**A19 Downhill Lane Junction Improvement**  
**Scheme Number: TR010024**  
**7.6(1) Application Documents Errata**

## APPLICATION DOCUMENTS ERRATA

<b>Regulation Number:</b>	Regulation 5(2)(q)
<b>Planning Inspectorate Scheme Reference</b>	TR010024
<b>Application Document Reference</b>	TR010024/APP/7.6(1)
<b>Author:</b>	A19 Project Team, Highways England & Jacobs

<b>Version</b>	<b>Date</b>	<b>Status of Version</b>
Rev 1	September 2019	Updated for Examination Deadline 2
Rev 0	July 2019	Post Application Issue

FIGURE 7.1

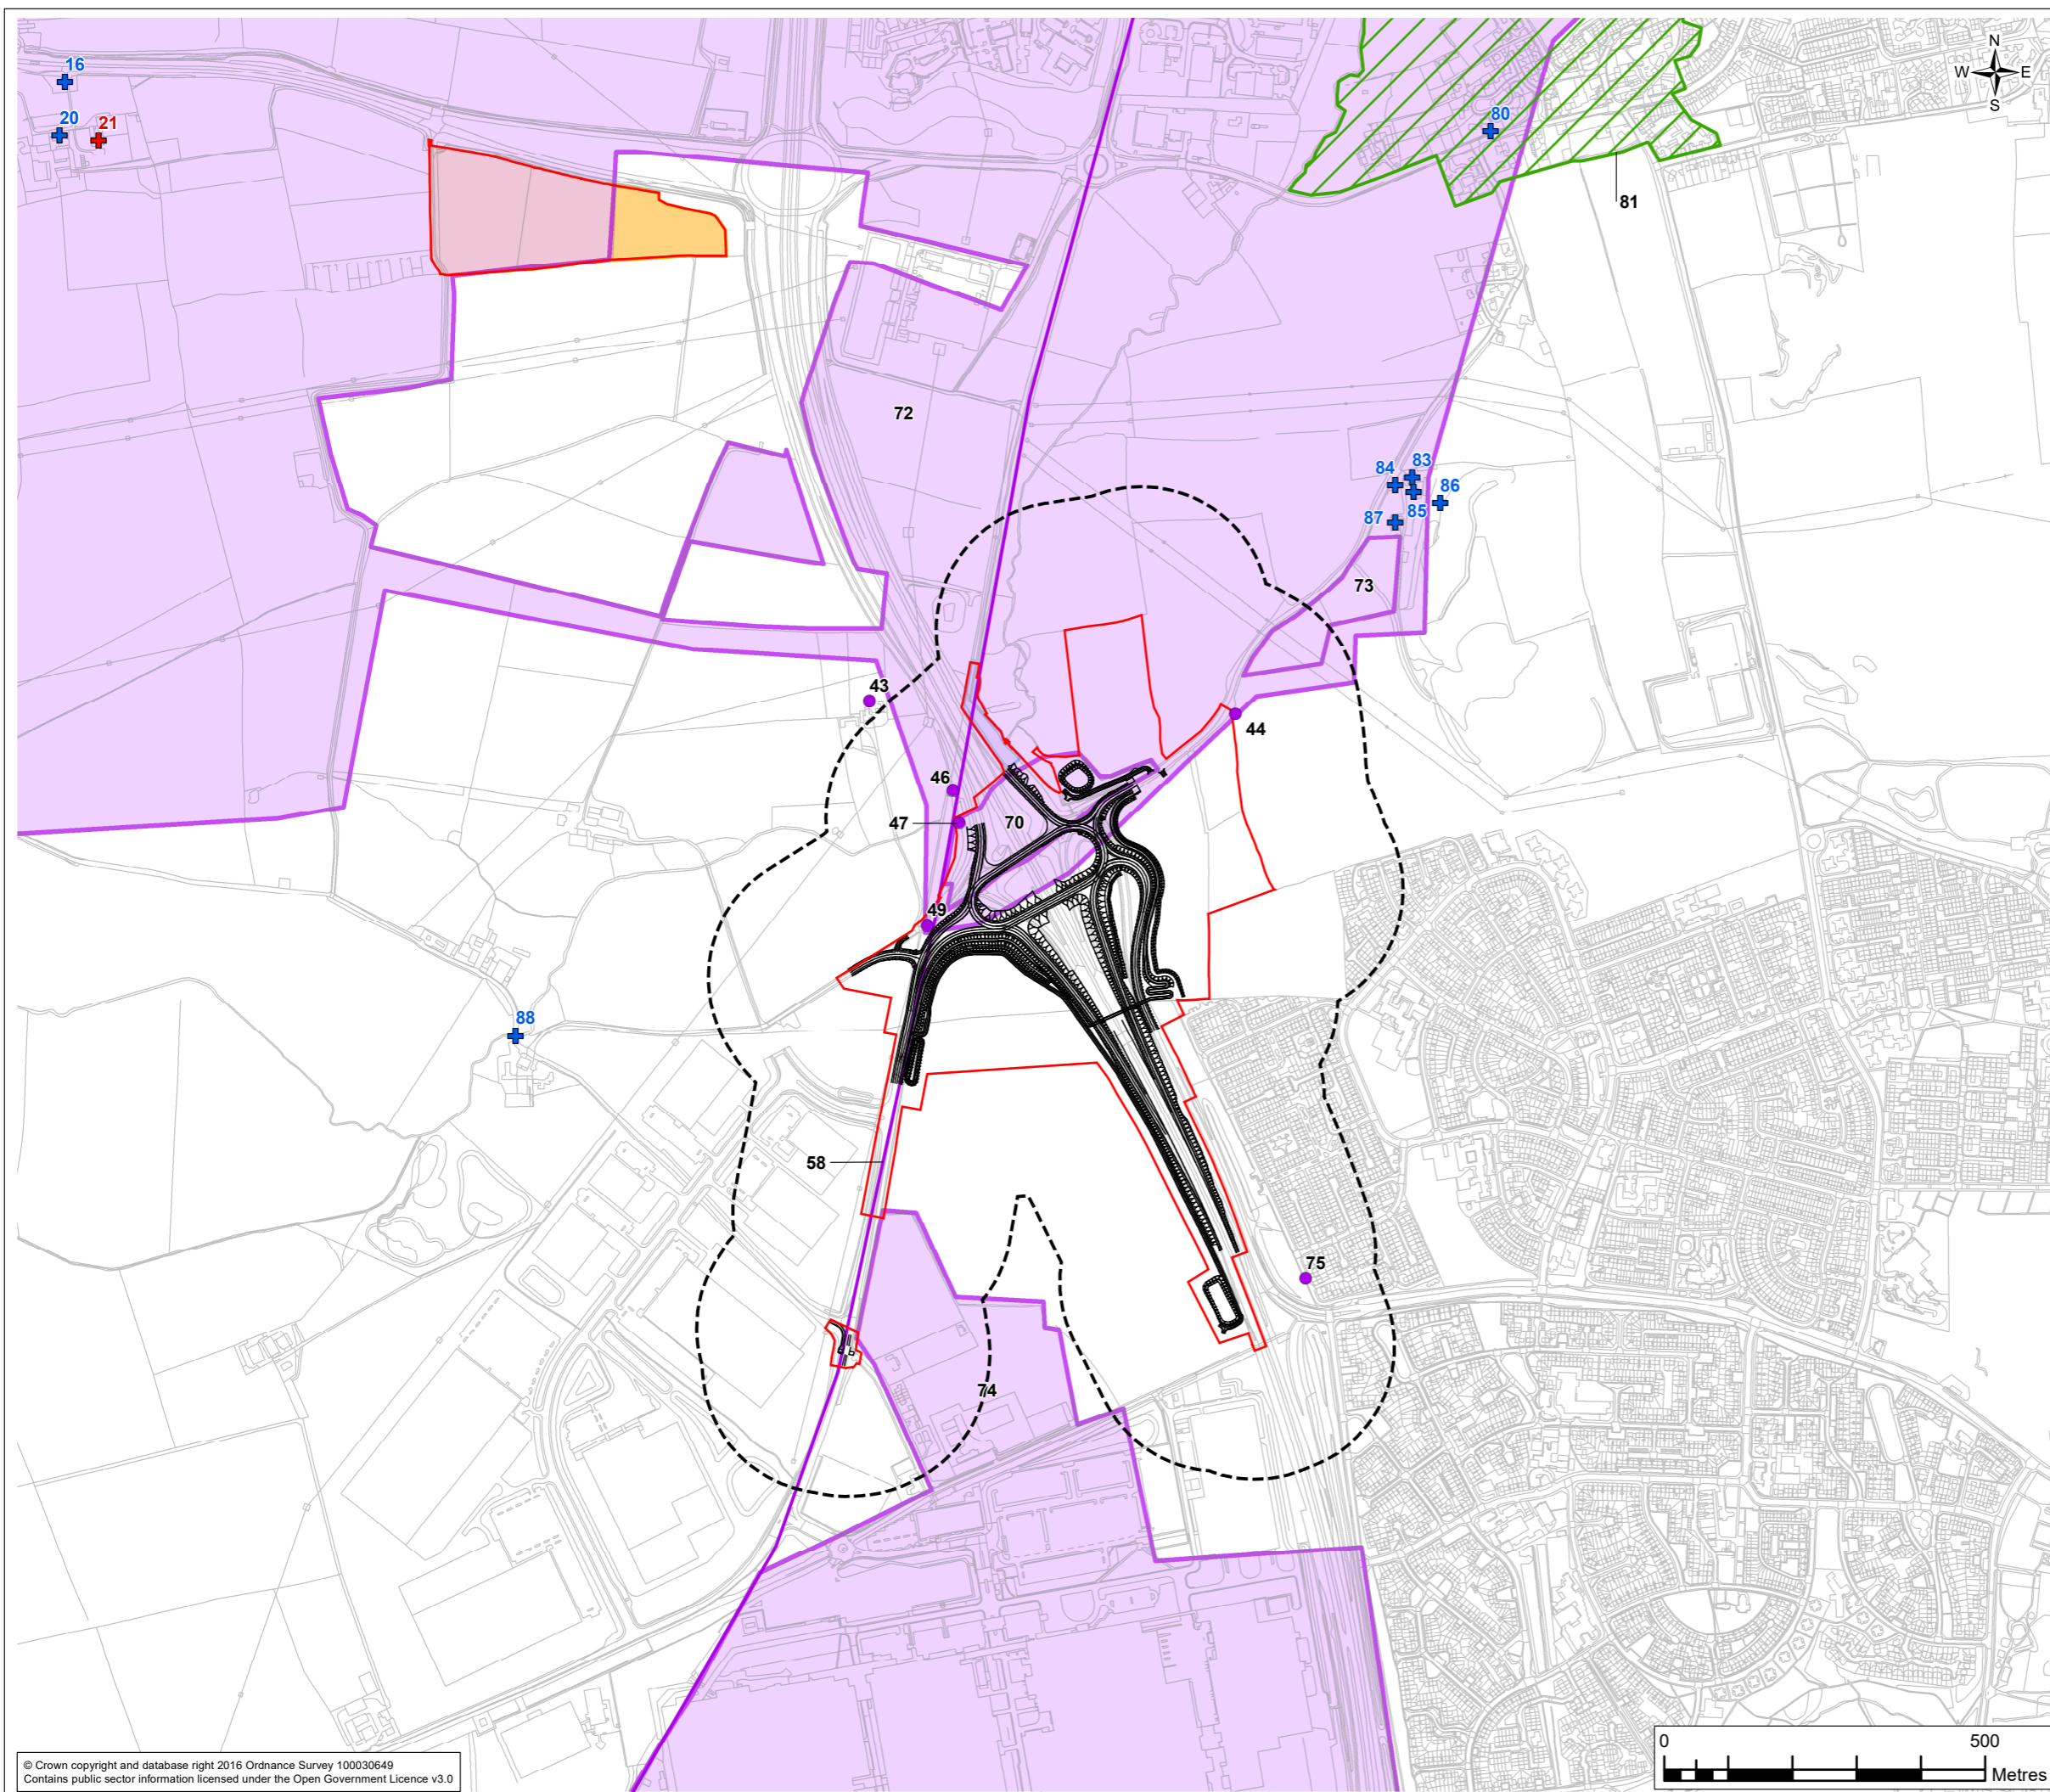
TR010024_APP_6.2 Environmental Statement Figures - Chapter 7 – Rev 0	Figure 7.1	N/A	<b>Old/Figure</b>	<b>New/Text</b>	<b>Asset Name</b>
			83	28	Downhill Farmhouse
			84	30	Pair of Lodge Cottages at entrance to Downhill house
			85	31	Barn and Gin Gang to South of Downhill Farmhouse
			86	33	Limekiln Southeast of Downhill Farmhouse
			87	35	Downhill House
			The figure has been corrected to reflect Table 7-6 in Chapter 7 of the Environmental Statement (TR010024/APP/6.1) [APP-020]. Accordingly, an updated version of Figure 7.1 (Rev 1) which includes the historic building references outlined

above can be found in Appendix A.
--	--	--	-----------------------------------
